Planning Inspectorate

Our Ref: EN020026

Date: 5 August 2025

Application by National Grid Electricity Transmission for an Order Granting Development Consent for the Sea Link Project

THE NATIONAL GRID (SEA LINK) ORDER  
 PINS APPLICATION NUMBER: EN020026  
 LAND PLANS - SUFFOLK  
 REGULATION 5(2)(i)-(iii)  
 SHEET 1 OF 7  
 IN THE DISTRICT OF EAST SUFFOLK DISTRICT COUNCIL

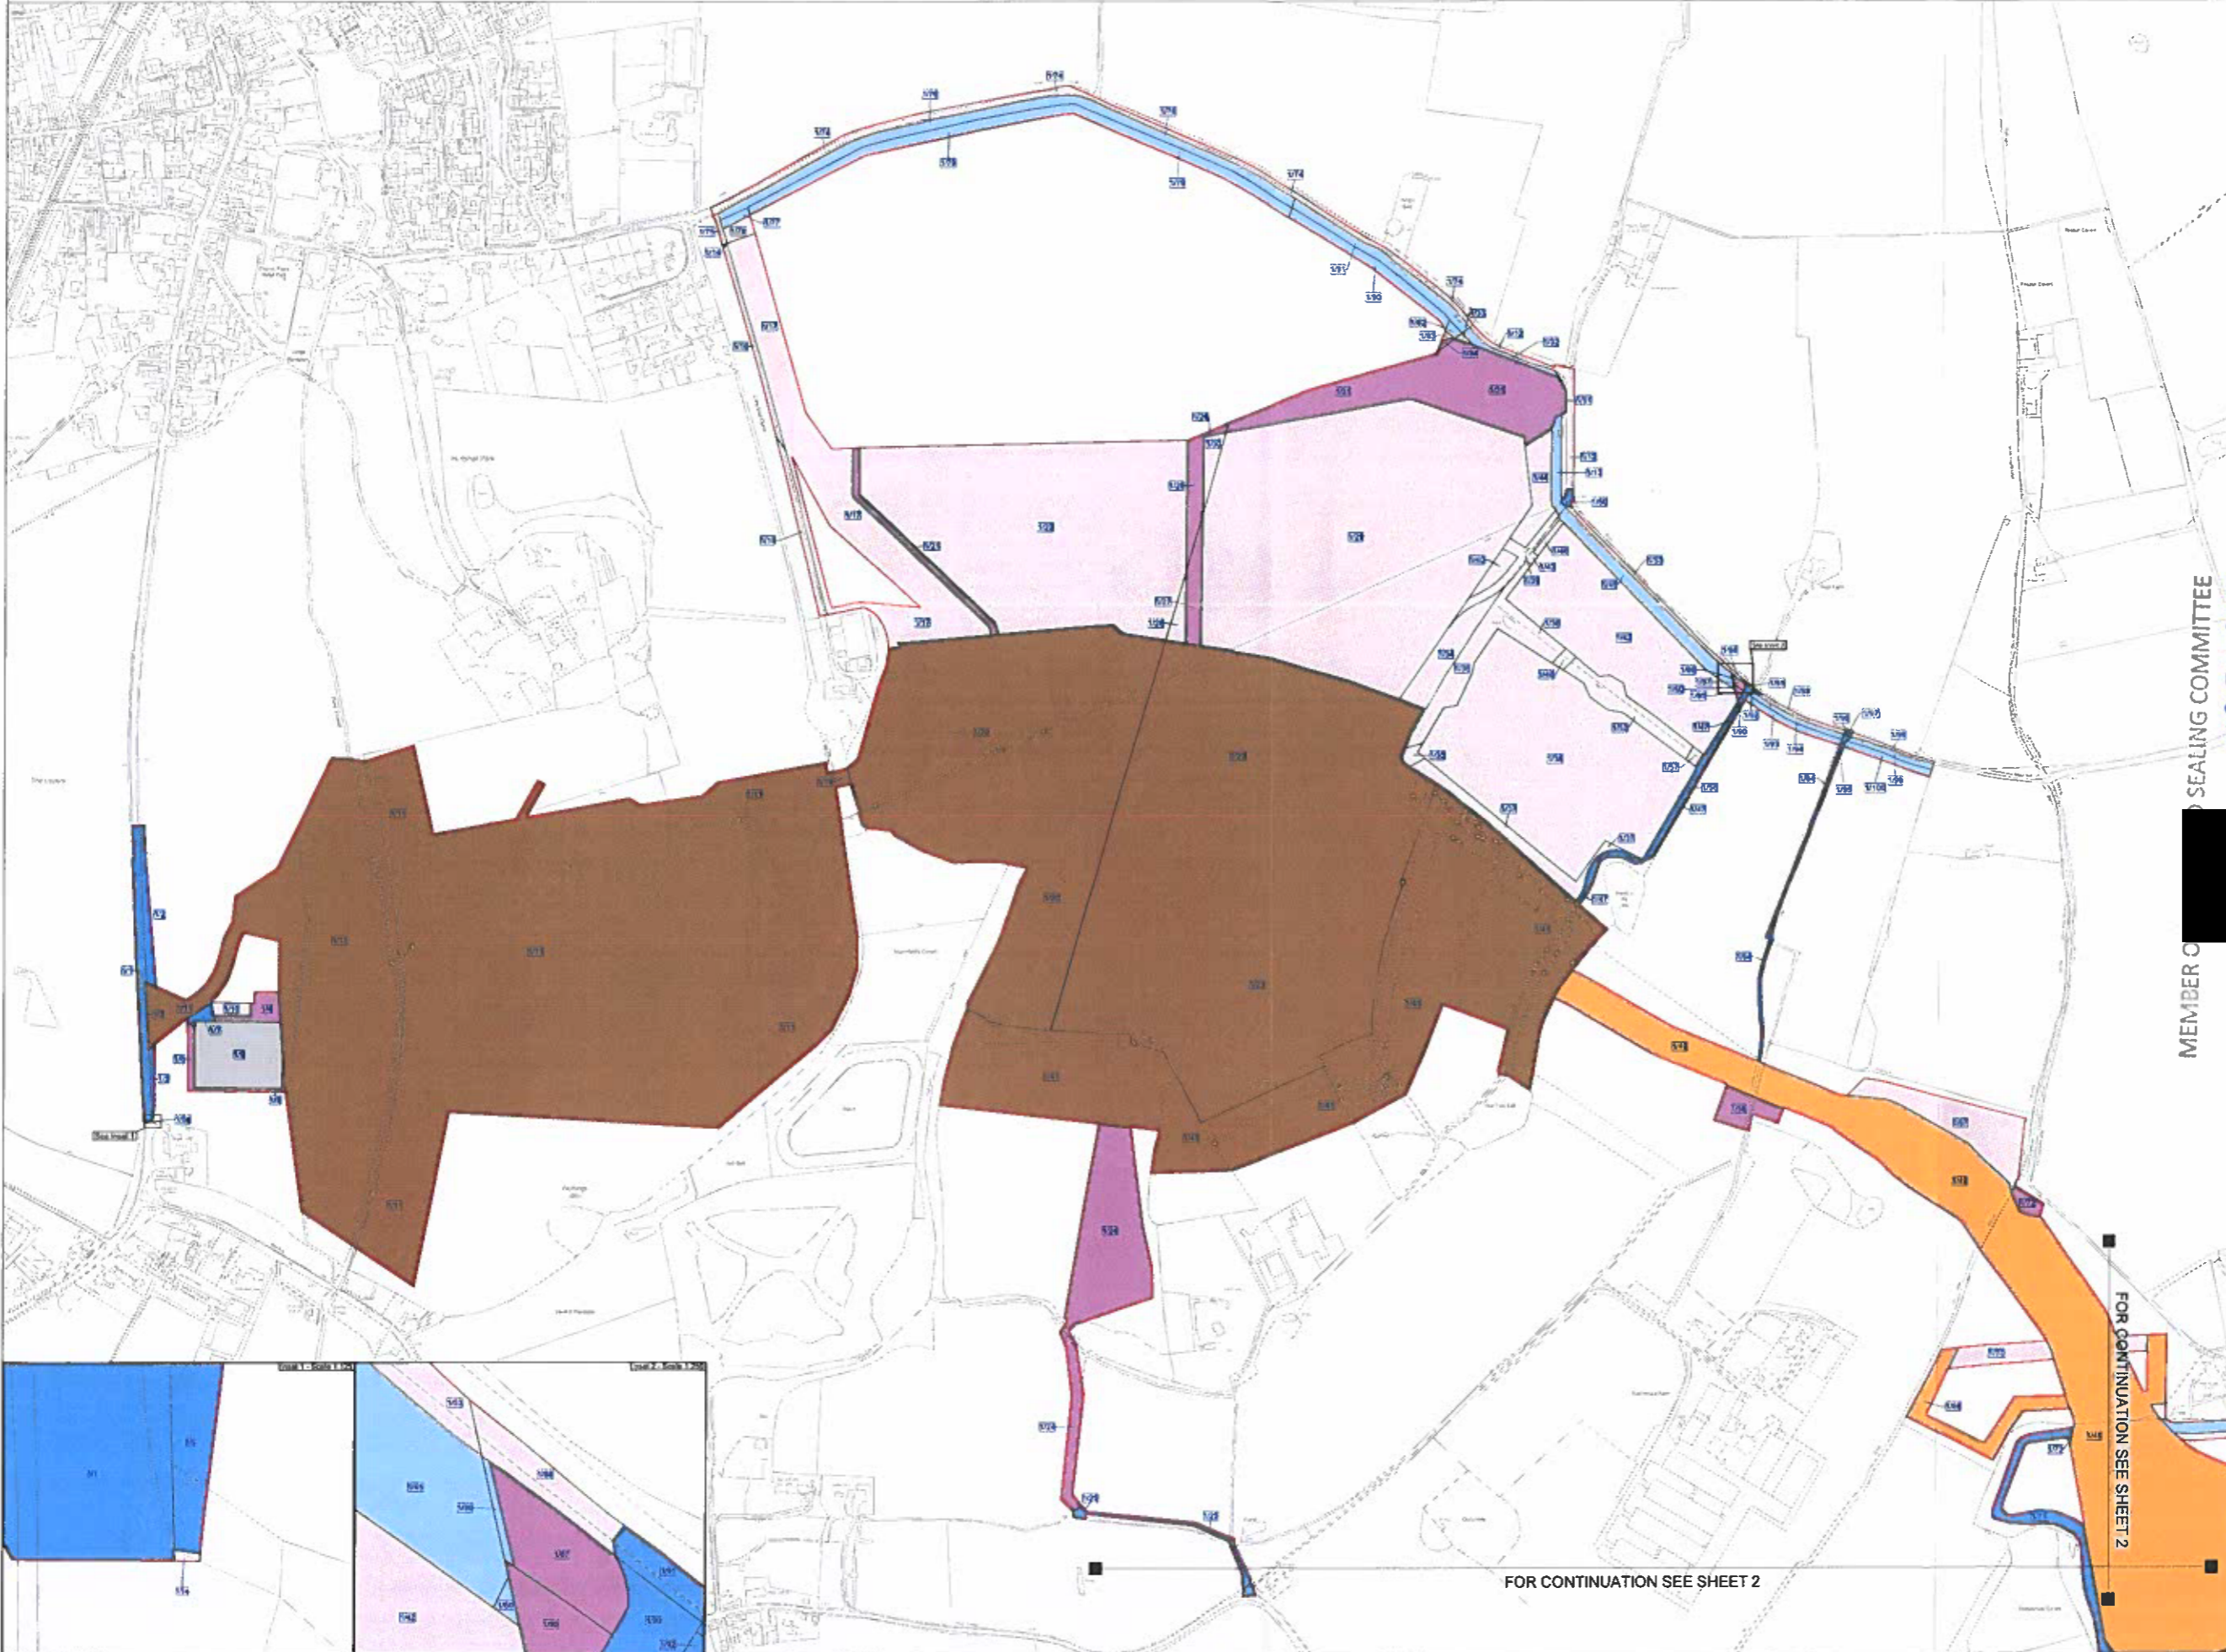
Plot 1/78 is shown on Sheet 1 of the Land Plans - Suffolk [APP-019] for class 5 compulsory acquisition of rights for access but is not mentioned in the Book of Reference

(BoR) [\[APP-016\]](#) or Statement of Reasons (SoR) Appendix A [\[APP-013\]](#). The ExA requests that Plot 1/78 is examined and any errors identified and resolved.
